# CITY OF ALBUQUERQUE

**Re: Lot 6 Block 4 Unit 18 Volcano Cliffs, S.A.D. 228  
6600 Papagayo NW  
Request for Permanent C.O. – Not Accepted  
Engineer's Stamp dated: 1-2-18 (D10D003J6)  
Certification dated: 1/23/19**

Based on the Certification received 1/23/19, this site cannot be accepted for release of Certificate of Occupancy by Hydrology until the following comments are addressed.

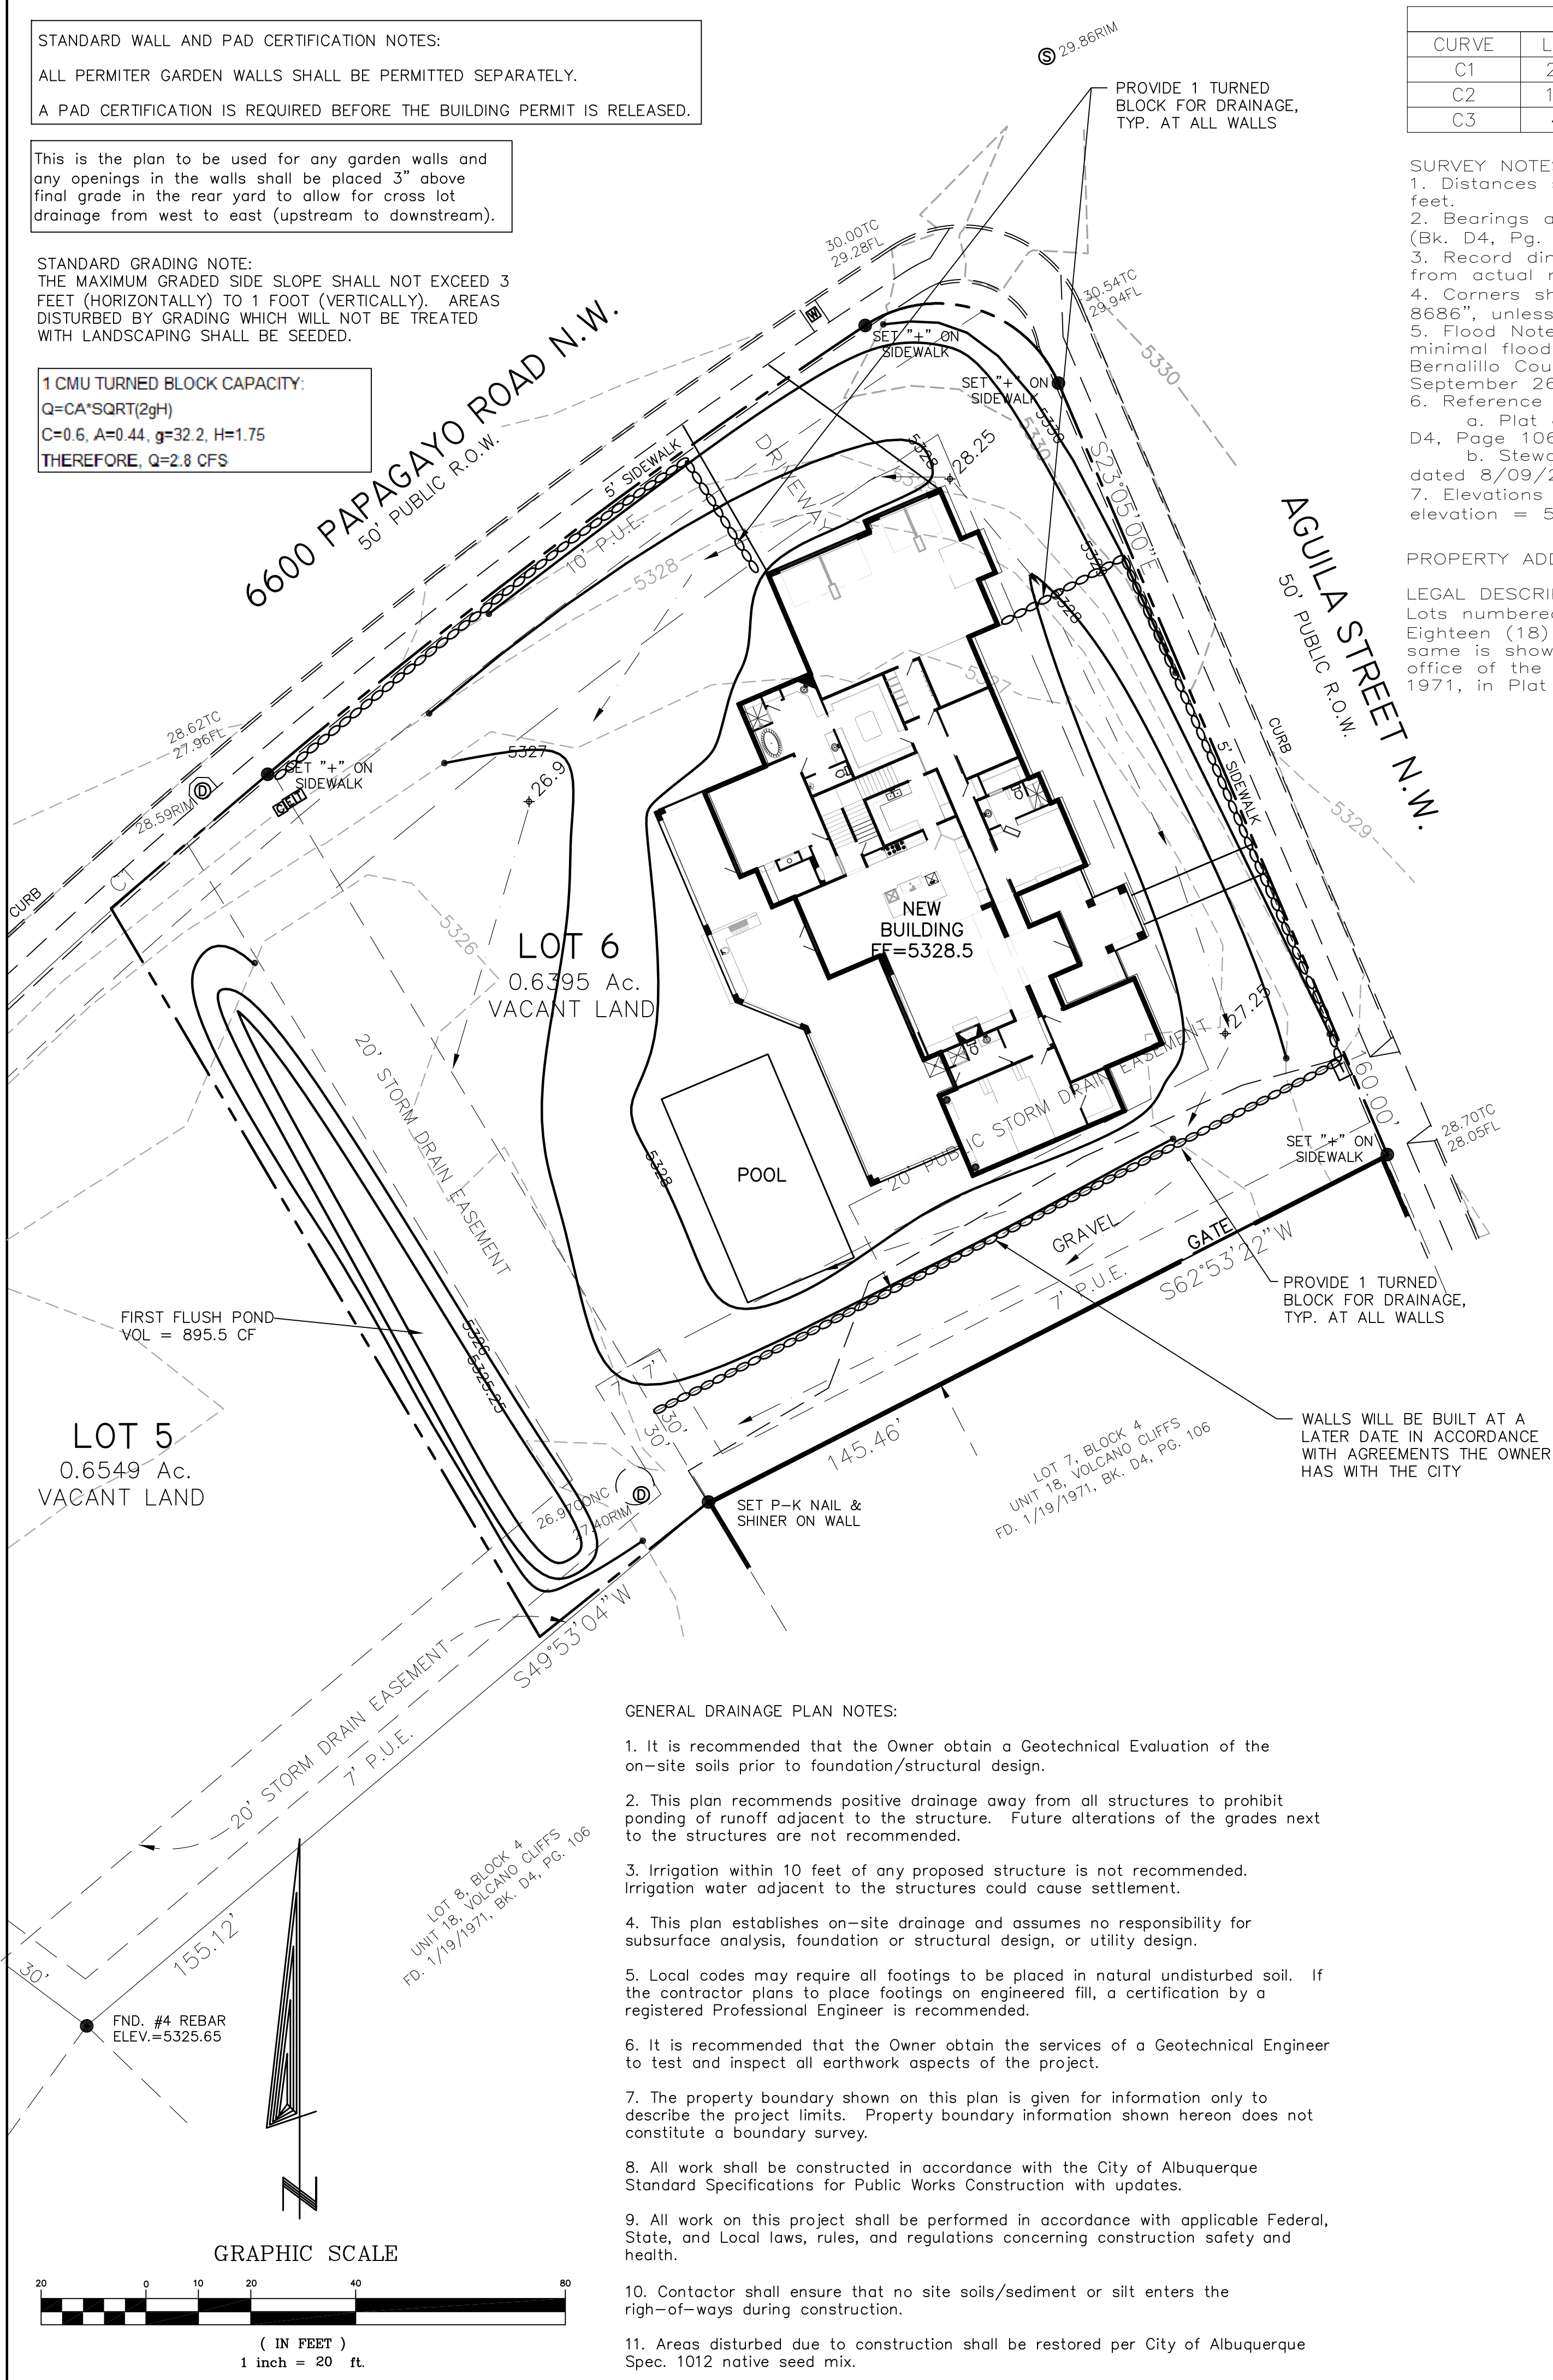
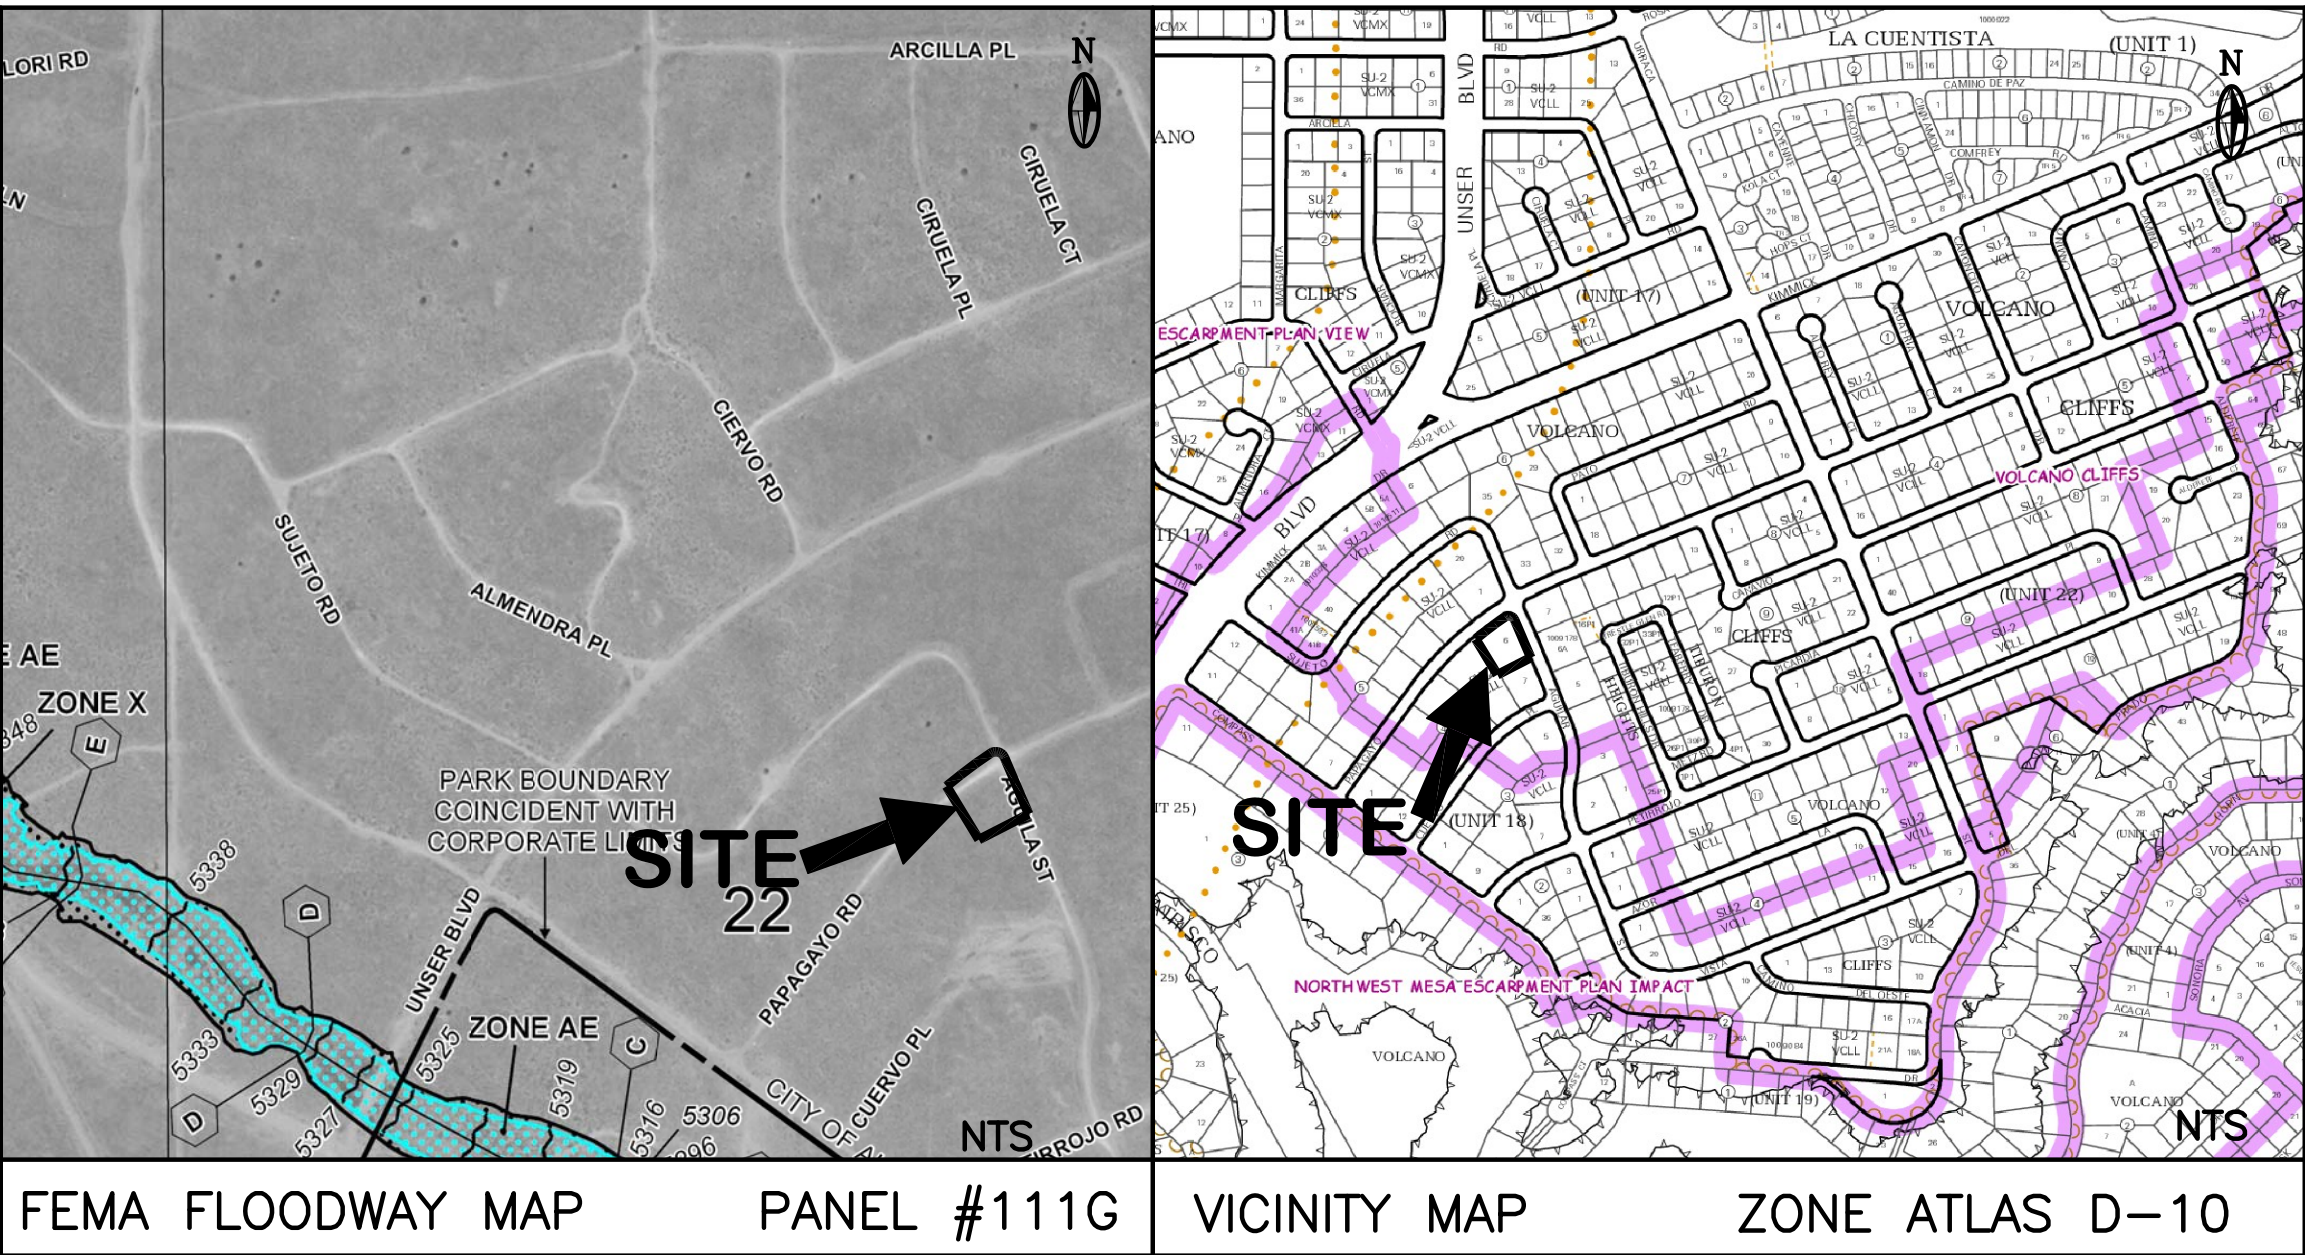
- Provide the new plat for this address, it appears that the lot line was moved.
- Provide the location of the 20' SD easement, one of the hatched lines are missing.
- Provide the new calculations including the pool area. Treatment D should have increase along with the ponding area.
